**Town and Country Planning Act 1990
Application for Permission to Develop Land**

Response from Pollution & Noise Control

PNC Reference No:	WK/201715608
Name of Planning Officer dealing with the matter:	Emma Thompson
Application Number:	2017/92315
Proposed Development:	Installation of air conditioning condensers and extract grilles (Unit 3B)
Location:	Fountain works, Fountain Court, Huddersfield Road, Roberttown, Liversedge, WF15 7QQ
Date Required By Planning:	17th August 2017

PROPOSED REAR ELEVATION 1:50

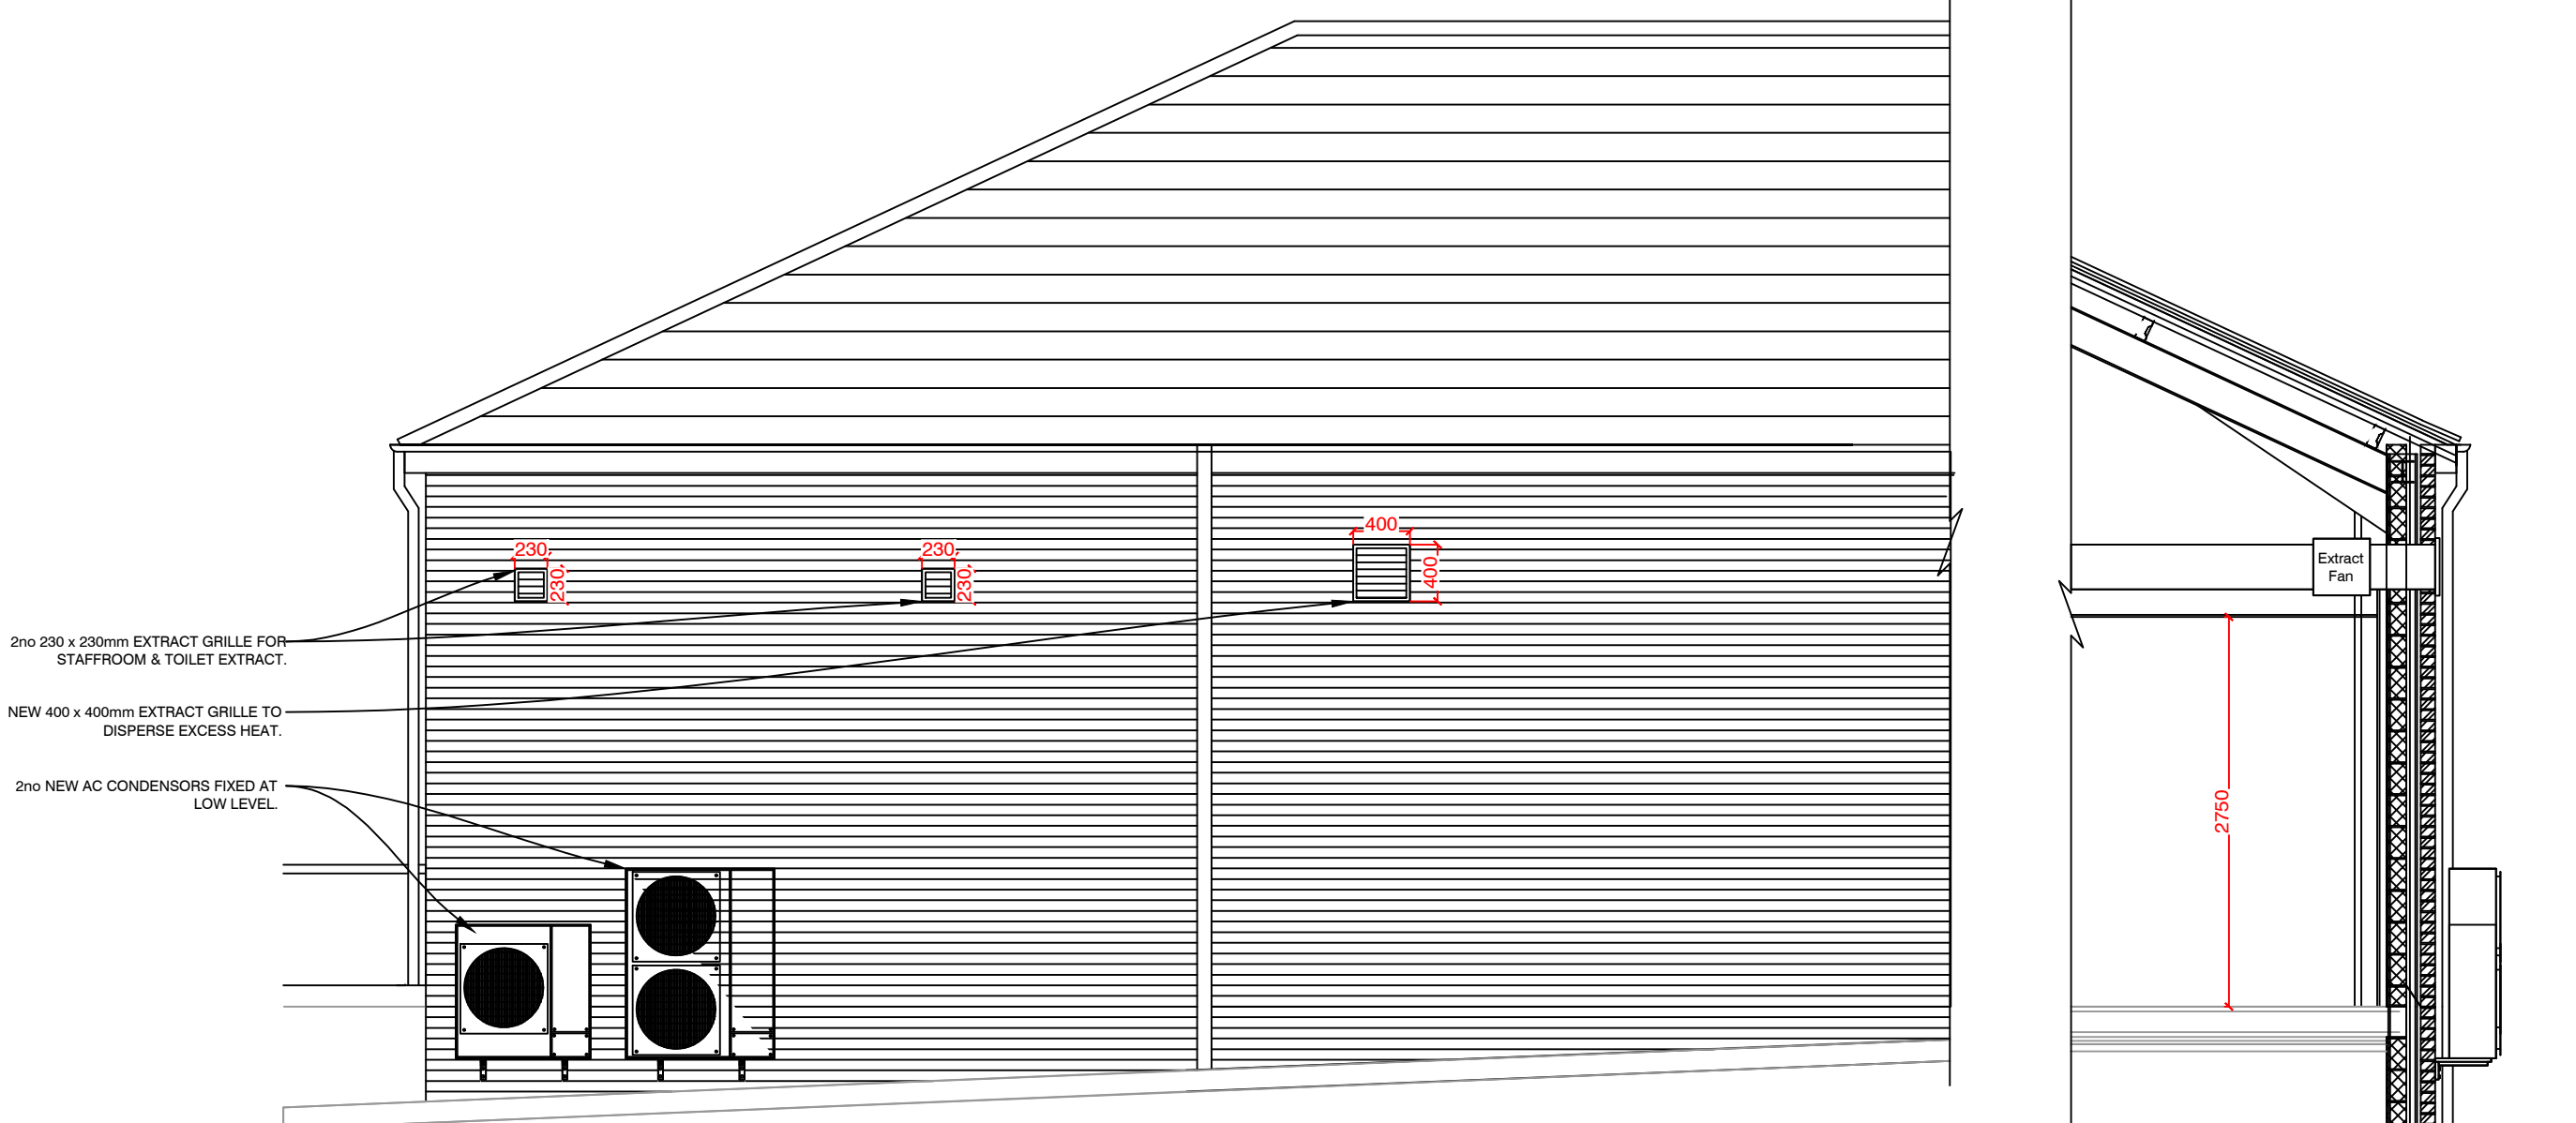
The proposed development of the installation of plant equipment is located in close proximity (within 10m of gardens and within 20m of façade) of residential properties at 12 to 26 (even numbers only) Ashby Close, Roberttown. I have concerns that noise from the plant equipment will impact on the amenity of these properties and therefore recommend the following condition.

Before development commences a report specifying the measures to be taken to protect the occupants of nearby noise sensitive premises 12 to 26 (even numbers only) Ashby Close, Roberttown from noise from the proposed development shall be submitted to and approved in

writing by the LPA. The report shall include

1. an assessment of noise emissions from the proposed development
2. details of background and predicted noise levels at the boundary of 12 to 26 (even numbers only) Ashby Close, Roberttown
3. a written scheme of how the occupants of 12 to 26 (even numbers only) Ashby Close, Roberttown will be protected from noise from the proposed development with noise attenuation measures as appropriate

The development shall not be brought into use until all works comprised within the measures specified in the approved report have been carried out in full and such works shall be thereafter retained .
